Consultation Response from KC, Highways Development Management (HDM)

2023/91116 Land off, Primrose Lane, Hightown, Liversedge, WF15

Erection of 67 dwellings

Date Responded: 10/07/23

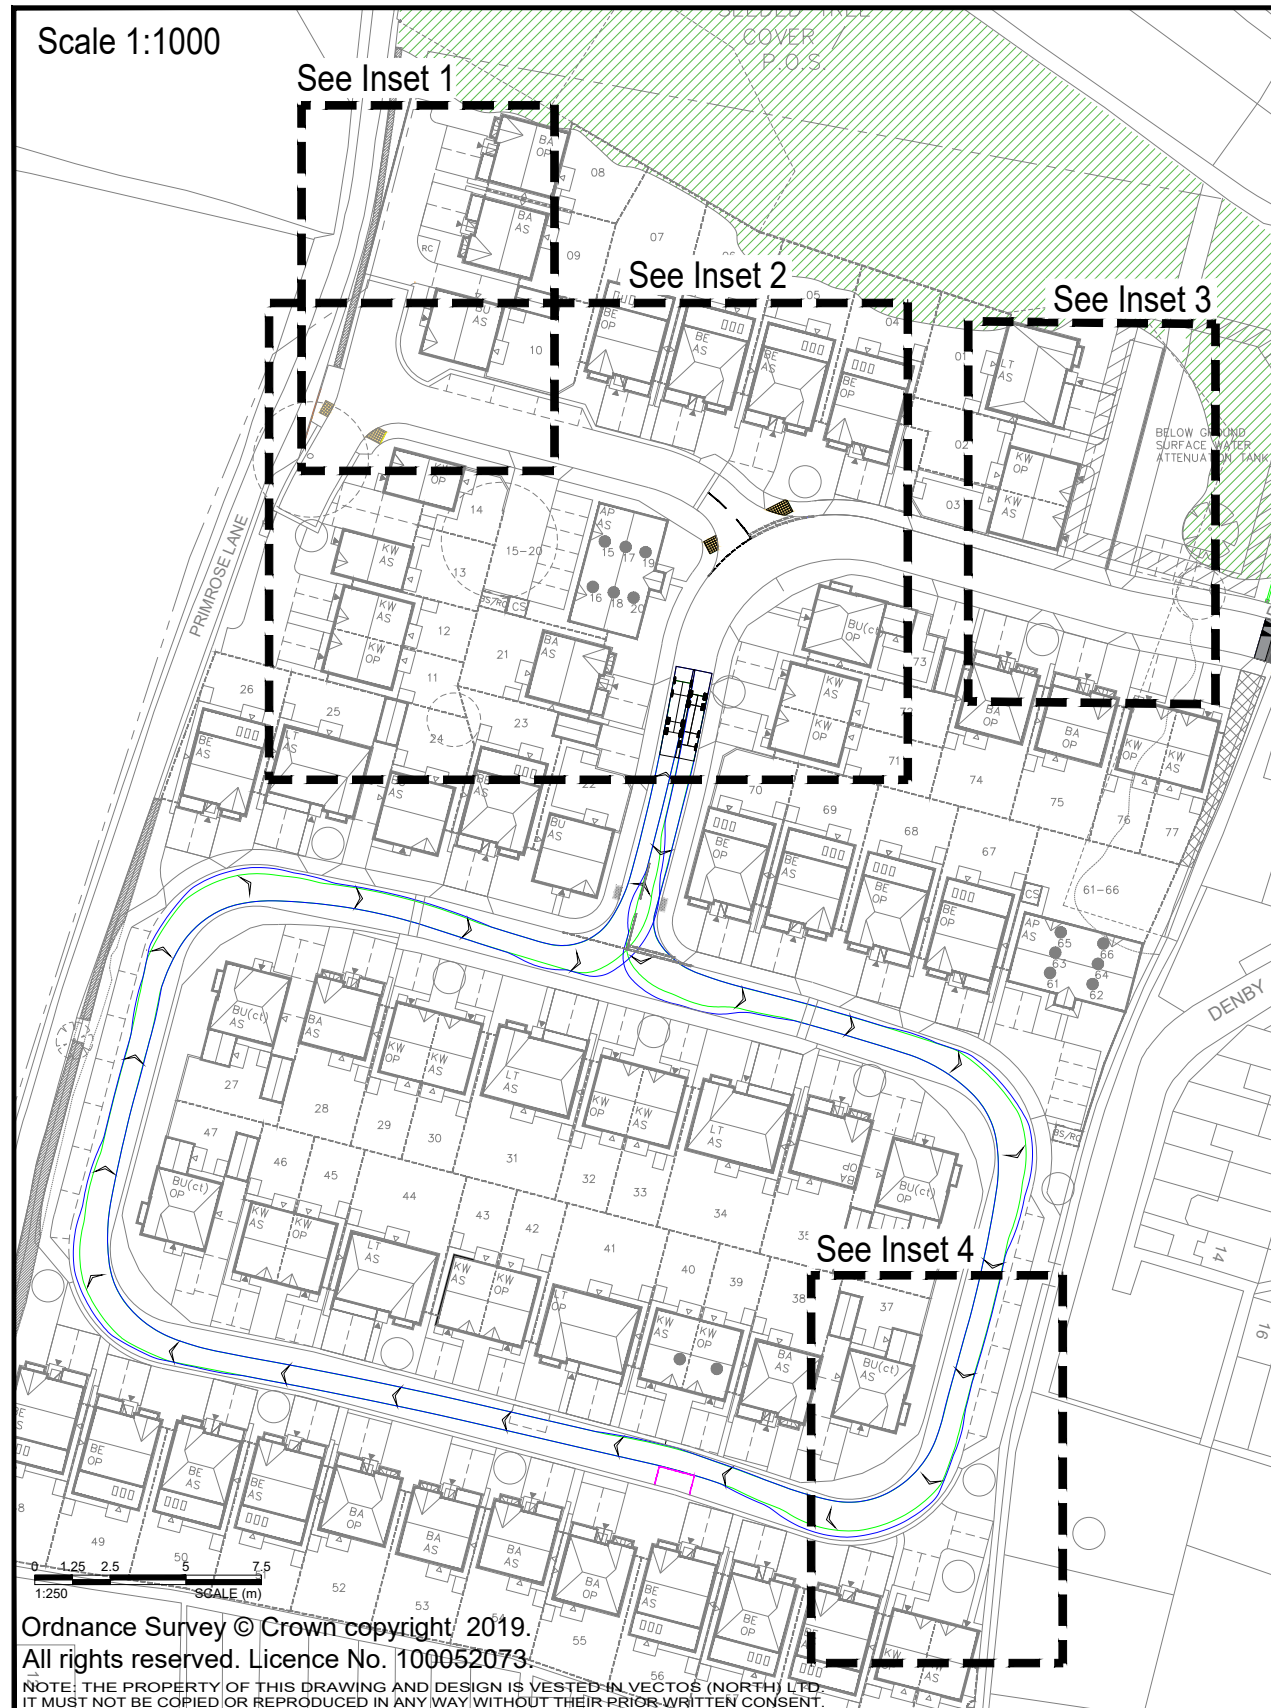
- The swept path analysis demonstrates that a refuse vehicle cannot pass a car at the bend adjacent to Plot 63. This bend should be widened to a minimum of 6.1m, and have a centreline radius of at least 20m, to ensure that vehicles can safely pass and obstructions to the refuse vehicle do not occur.

- Updated Swept path analysis of revised layout, including the new turning head that is required for the cul-de-sac serving Plot 4-9.
- Any retaining features affecting the highway (including PROW) need to be clearly identified, and sufficient detail provided to ensure that they are suitable in principle.
